From:	Neville, Julie <julie.neville@lancashire.gov.uk></julie.neville@lancashire.gov.uk>
Sent:	10 December 2024 17:20
То:	Planning
Subject:	3/2024/0911 Hough Clough Farm Houghclough Lane Chipping PR3 2NT
Attachments:	3 2024 0911 Overlay.pdf

Reference Location Proposal 3/2024/0911 Hough Clough Farm Houghclough Lane Chipping Preston PR3 2NT Proposed single-storey side extension to form garden room, dining area and utility room.

Lancashire County Council Public Rights of Way Team raises no objection to the application and provides the following.

Drawing Title  
**Proposed Site Plan**

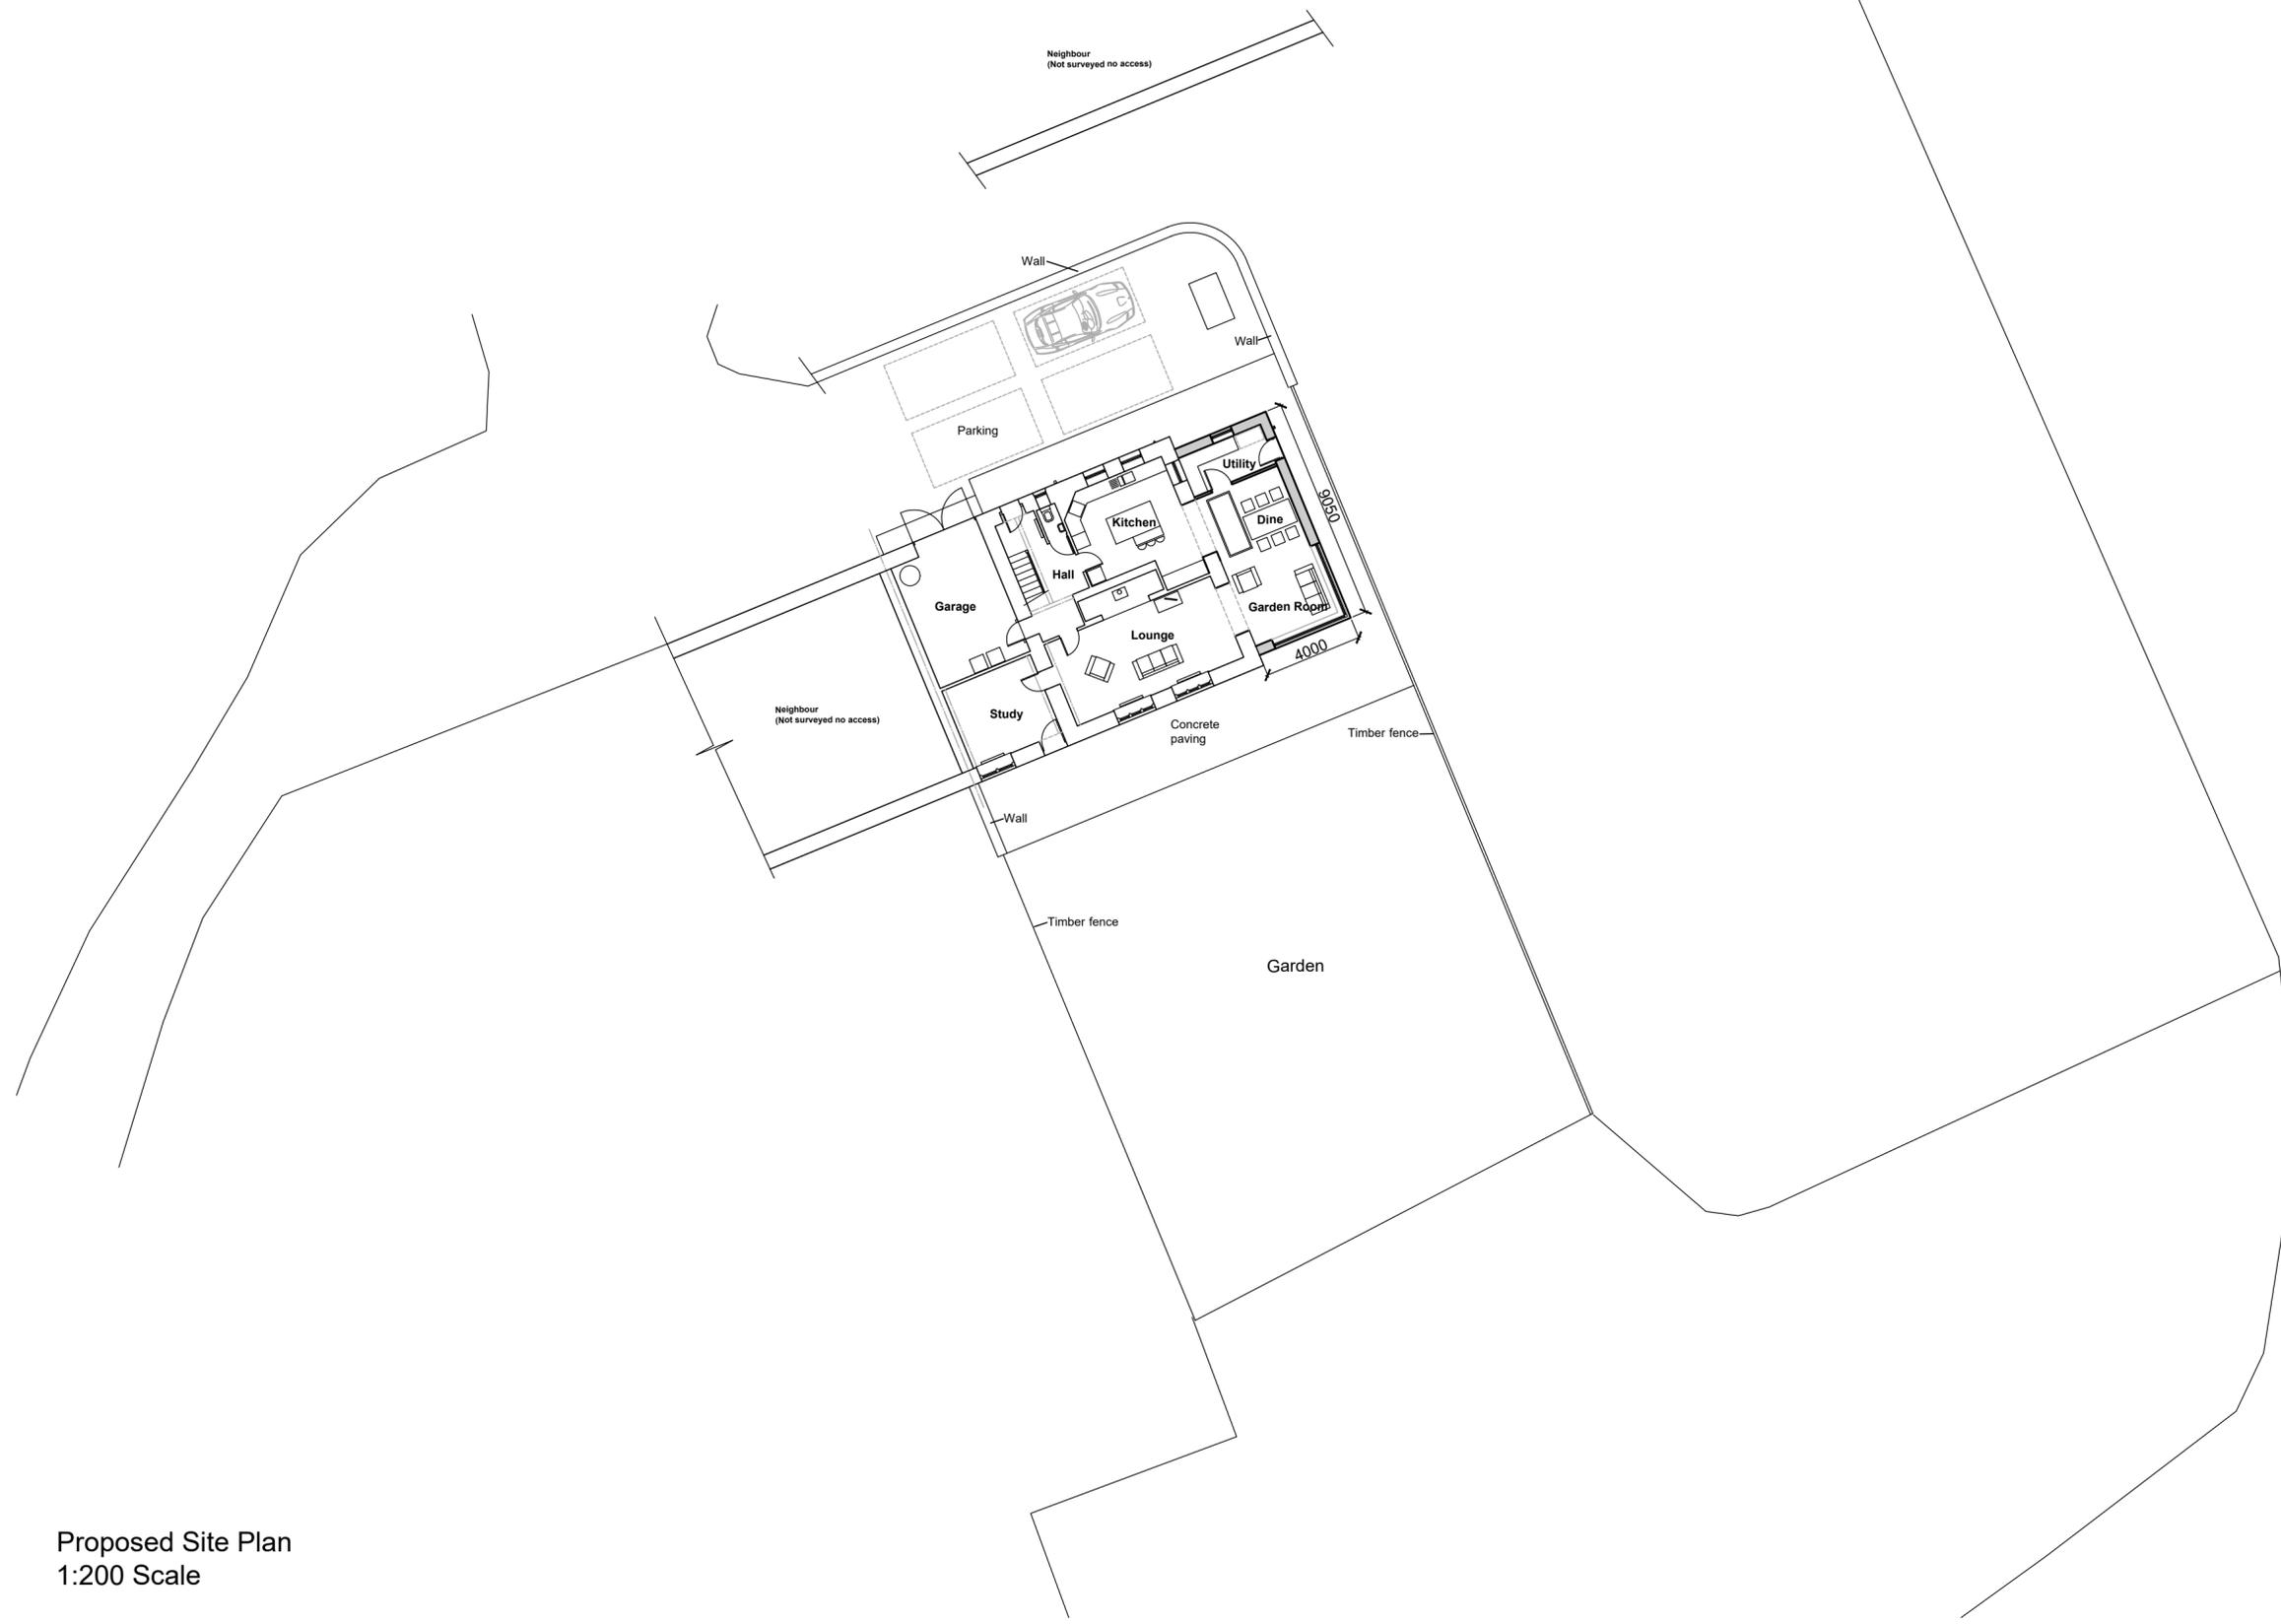
Footpath FP0312055 passes through the proposed parking area for the dwelling, as shown on the attached plan. The infringement or obstruction of the existing public rights would be a criminal offence, as such the right of way should always remain clear of parked vehicles and not used to store materials, machinery.
